CITY OF ALBUQUERQUE

RE: Copper Townhomes

Grading & Drainage Plan

Engineer's Stamp Date 8-15-16 (File: K17D111)

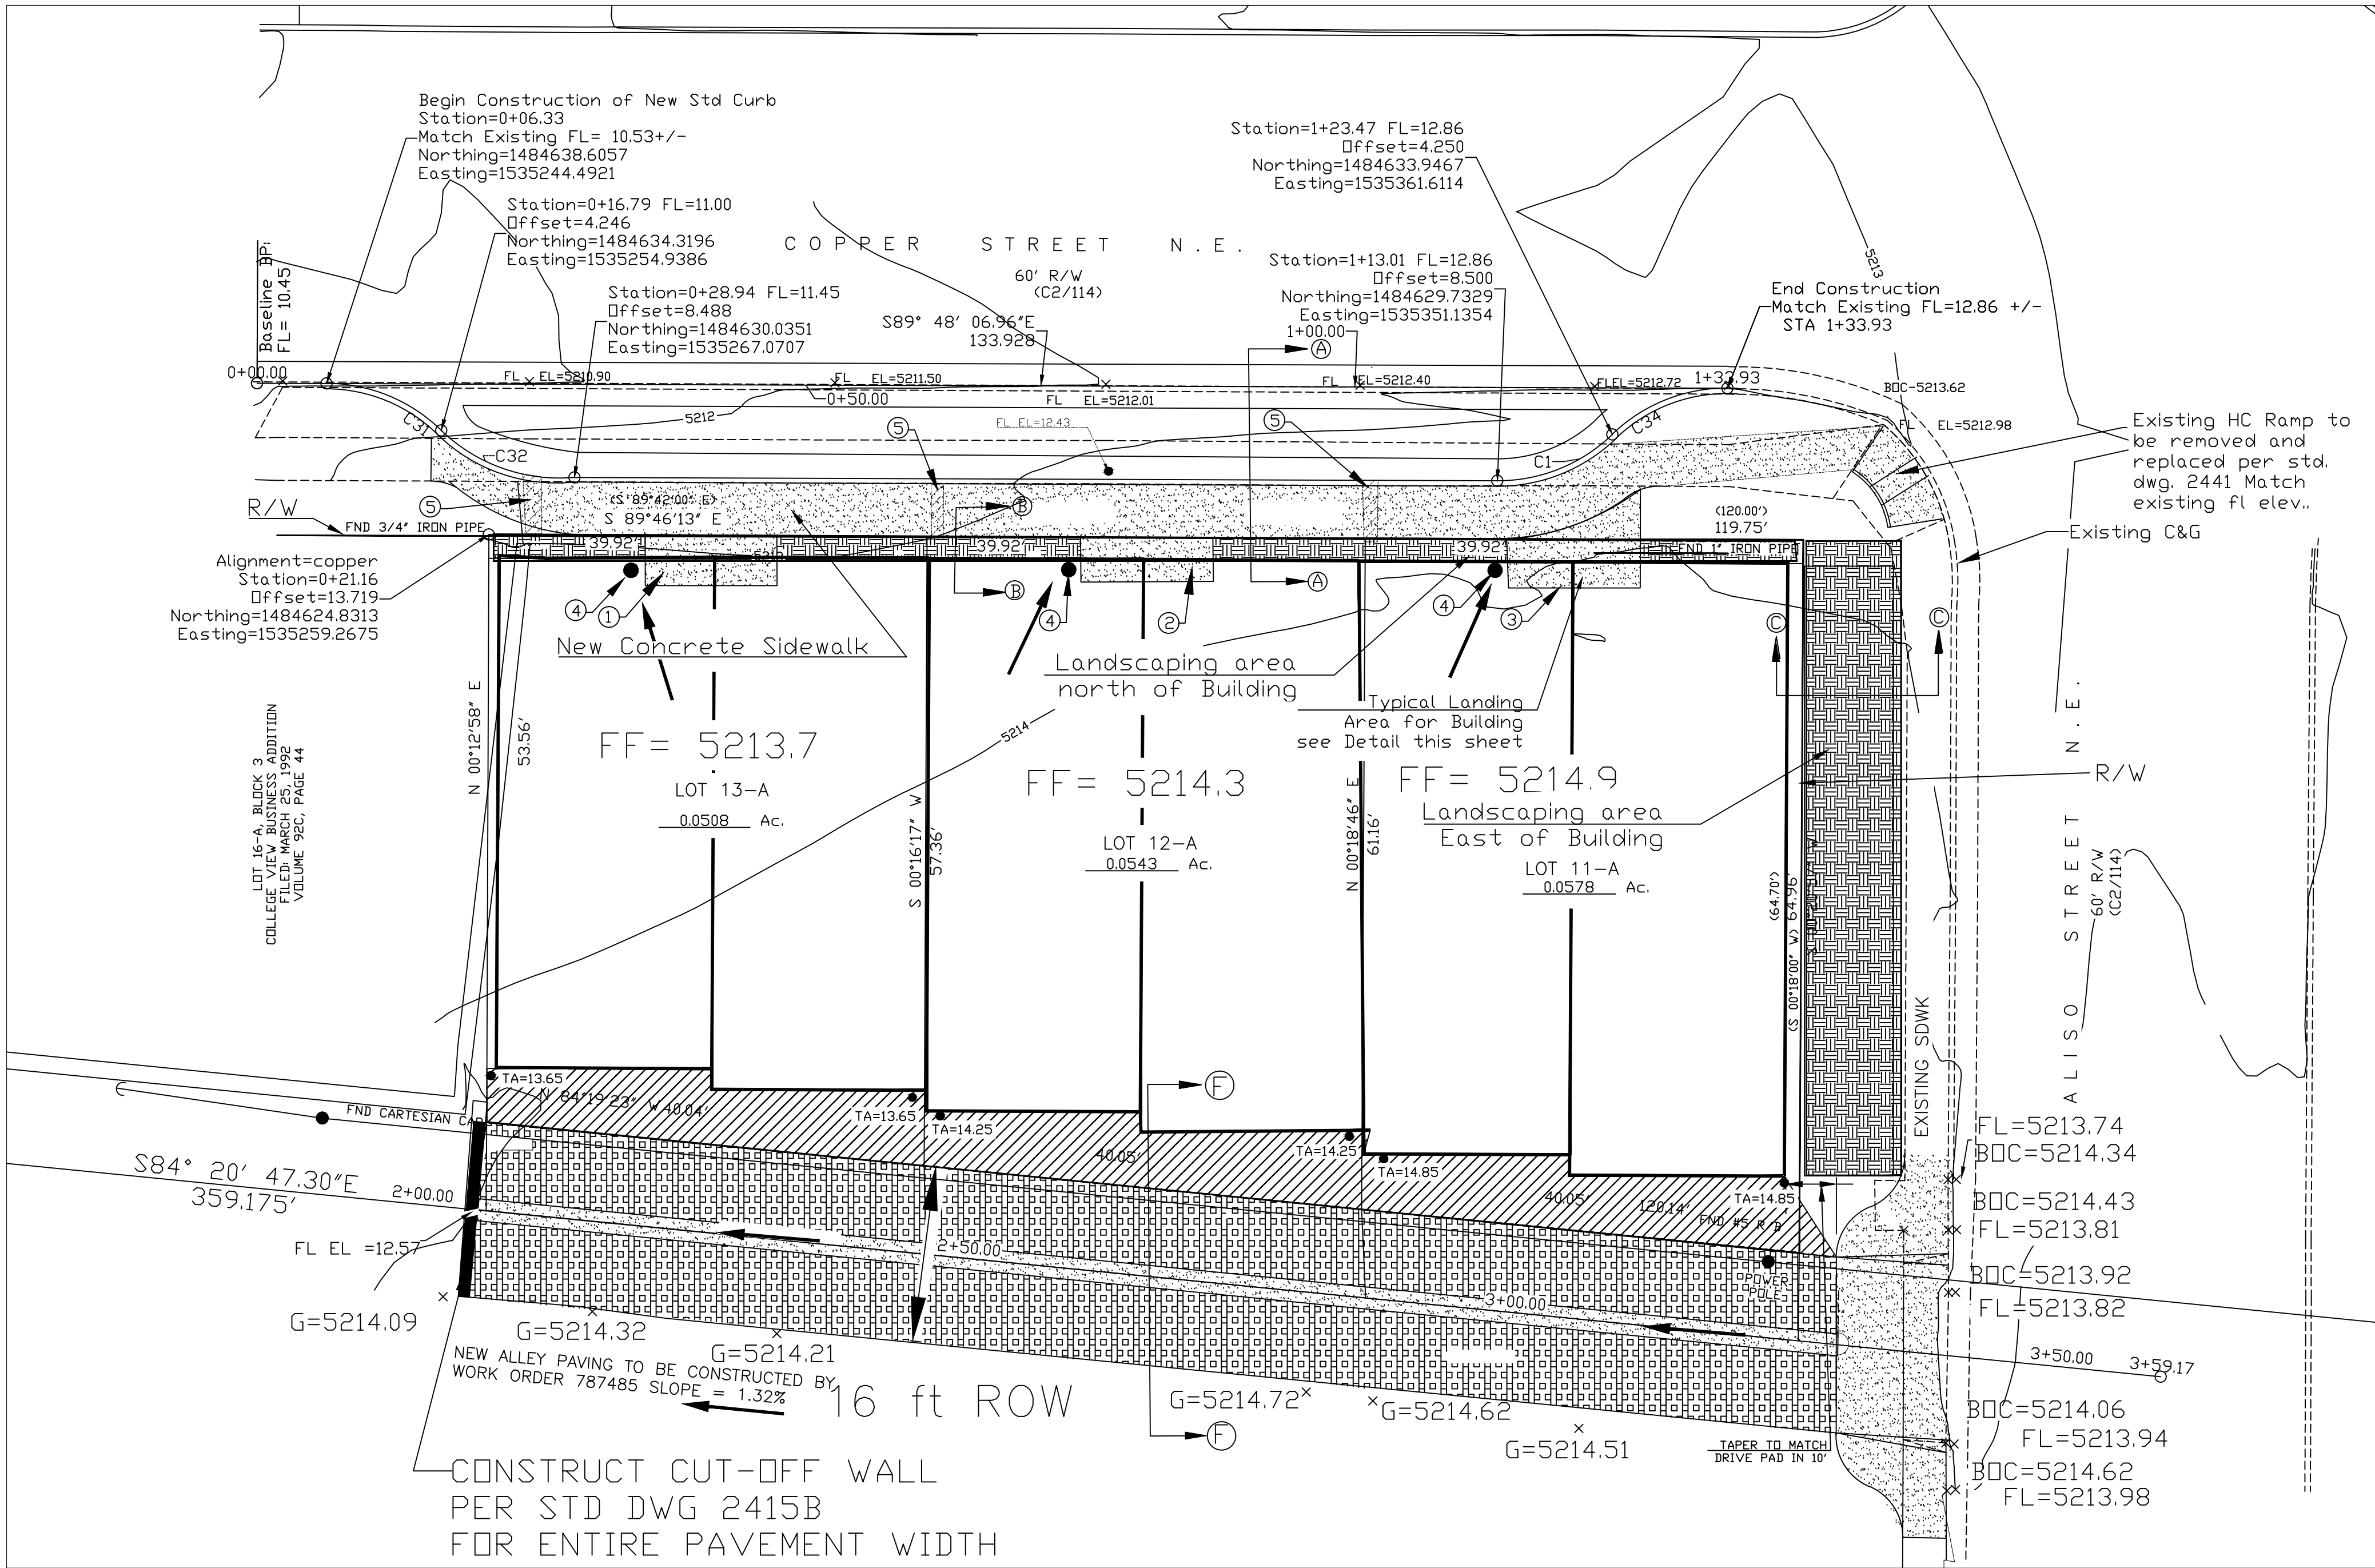
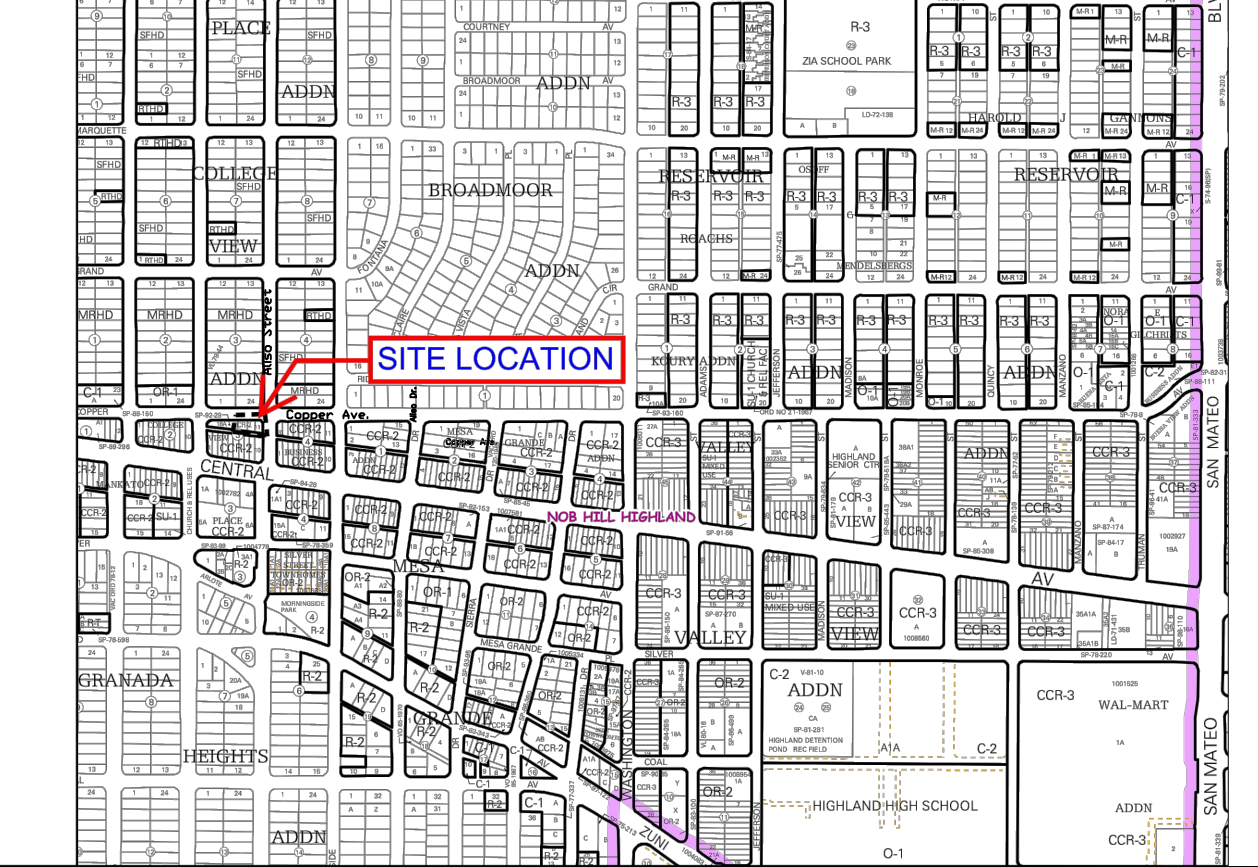
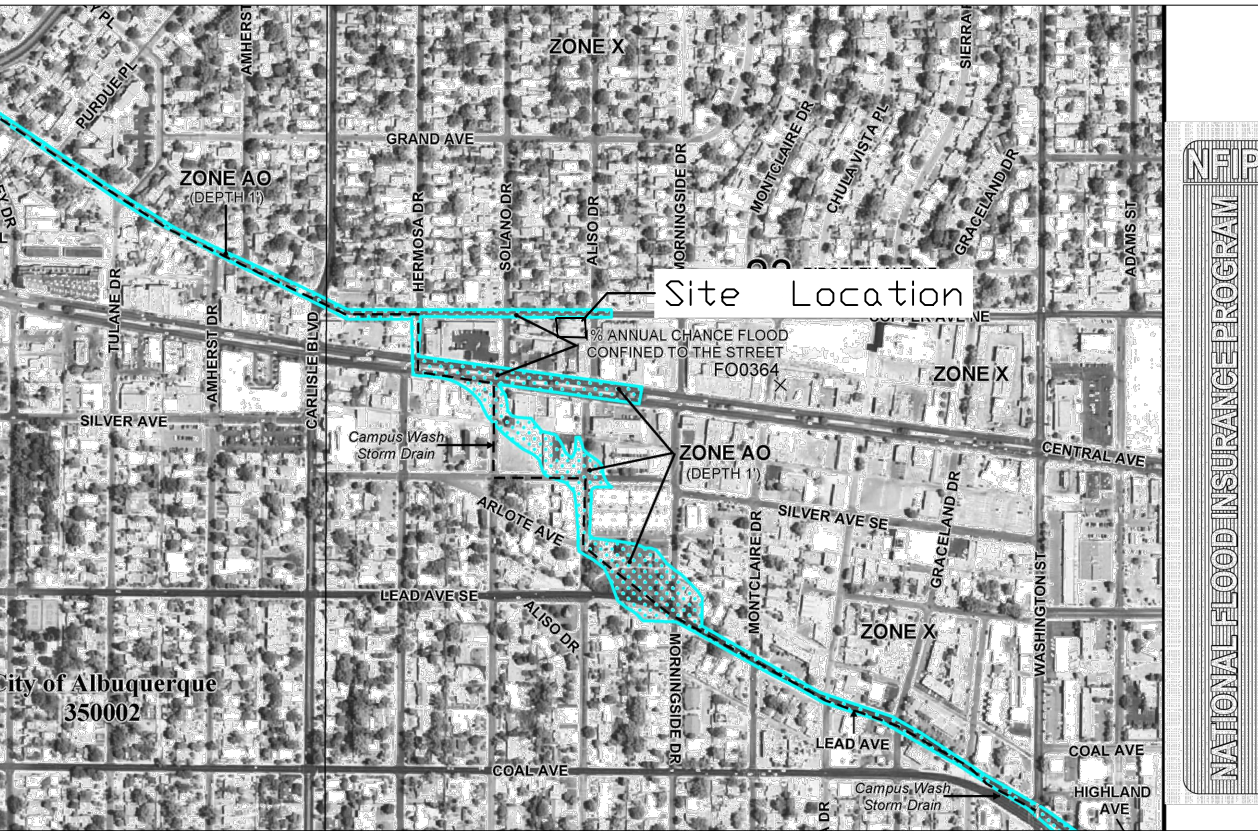
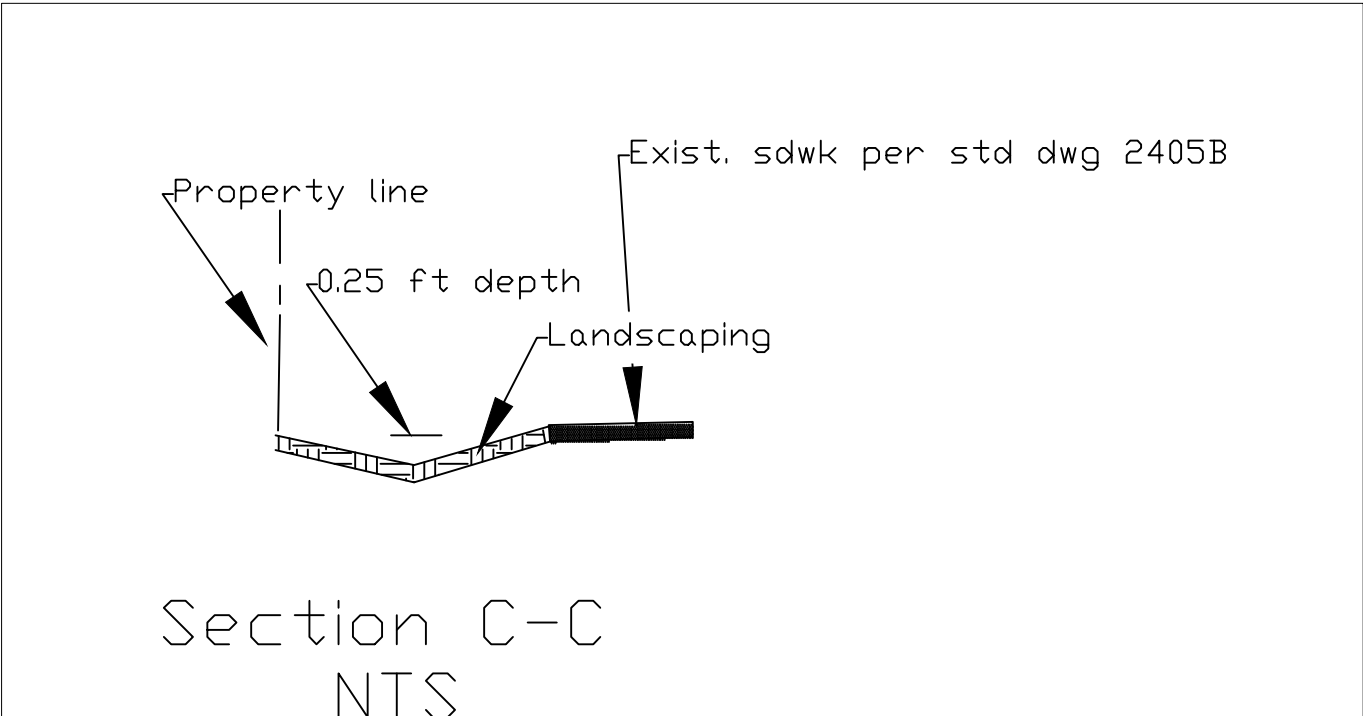
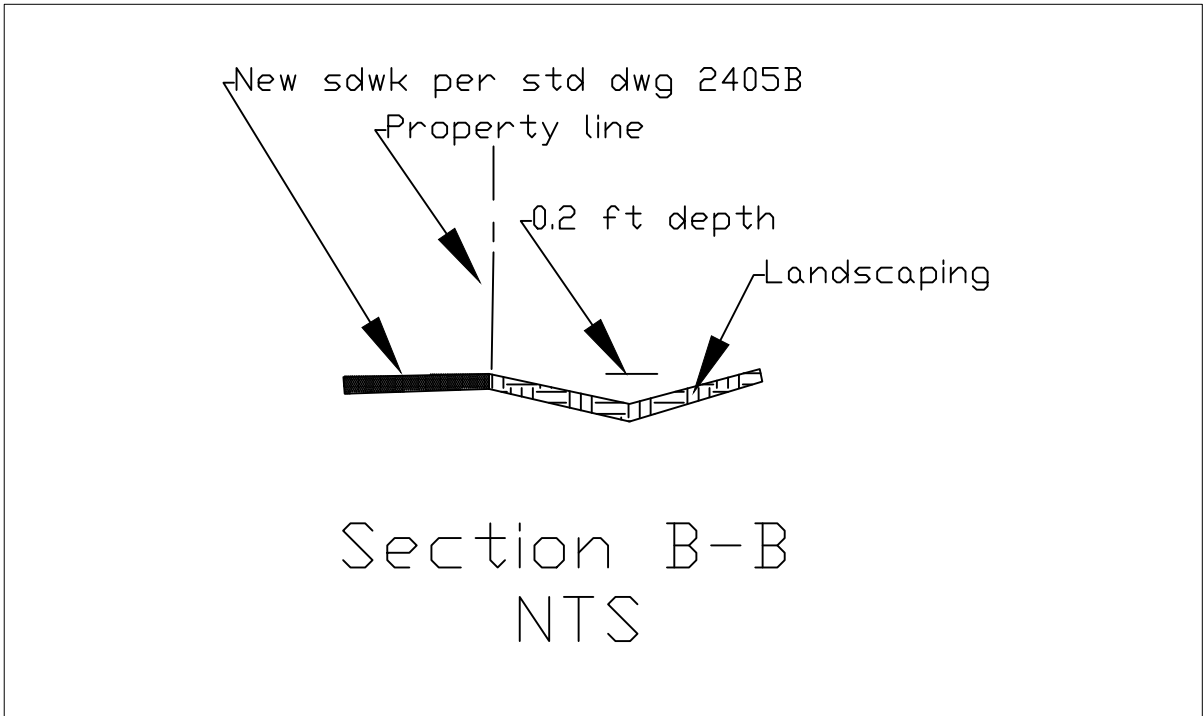
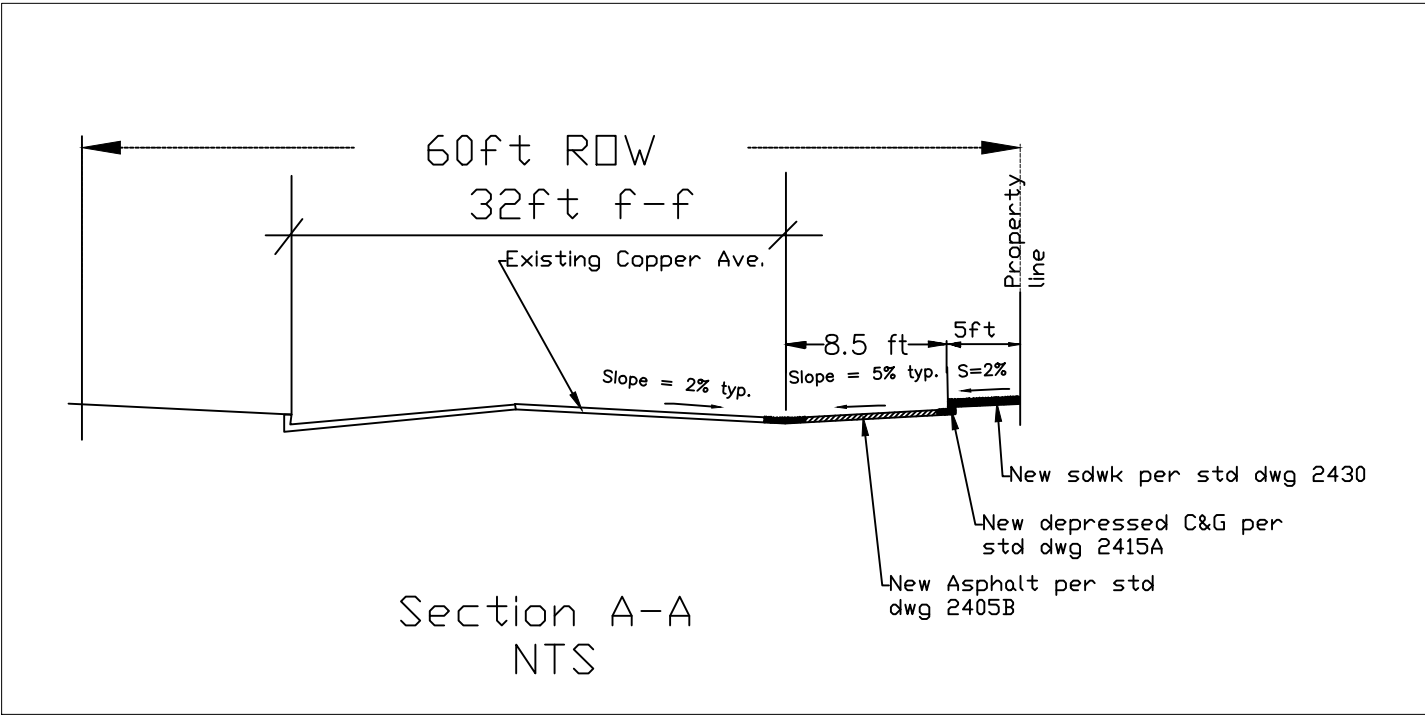
a. A wall appears to be encroaching into the proposed building on Lot 13-A.

b. There are dimensions shown that are floating on the plan without leader lines (39.92', 120.14', 40.05', etc).

- c. The building landing notes show a single elevation and it's not clear where it is to be set. Furthermore, consider incorporating a minimum slope to prevent nuisance ponding/ice patching near the building entrance, (the single elevation suggests that it is to be laid flat).
- d. The landscape buffers appear to be shown flat graded along the north face of the buildings; are they intended to drain? The sidewalk culverts have no build notes or dimensions, and they are offset from the apparent roof drain locations.
- e. Disconnected and broken line work implies that the electronic drawing might have issues that the Contractor will need assistance with in the field (if the contractor uses the electronic file for staking).

- f. Major elements of the project that are shown to be described in the DRC Set are not properly defined in the DRC Set (these items will need to be corrected on the DRC Set):
 - i. There is little direction for the Contractor on how to lay out the horizontal geometry of the unattached sidewalk, and the dimension of the west tie in appears to be approximately 2.75 feet wide.
 - ii. The way the driveway on Aliso is drawn is not constructible.
 - iii. The edge of pavement to edge of pavement dimension for the alley section is 16 feet. The cut off wall is outside of this dimension along the southern edge, so it will be encroaching into the adjacent property.
 - iv. There is no direction on how to construct the 6" swale in the unimproved segment of the alley (to prevent the contractor from just dropping a blade through the middle of the alley).
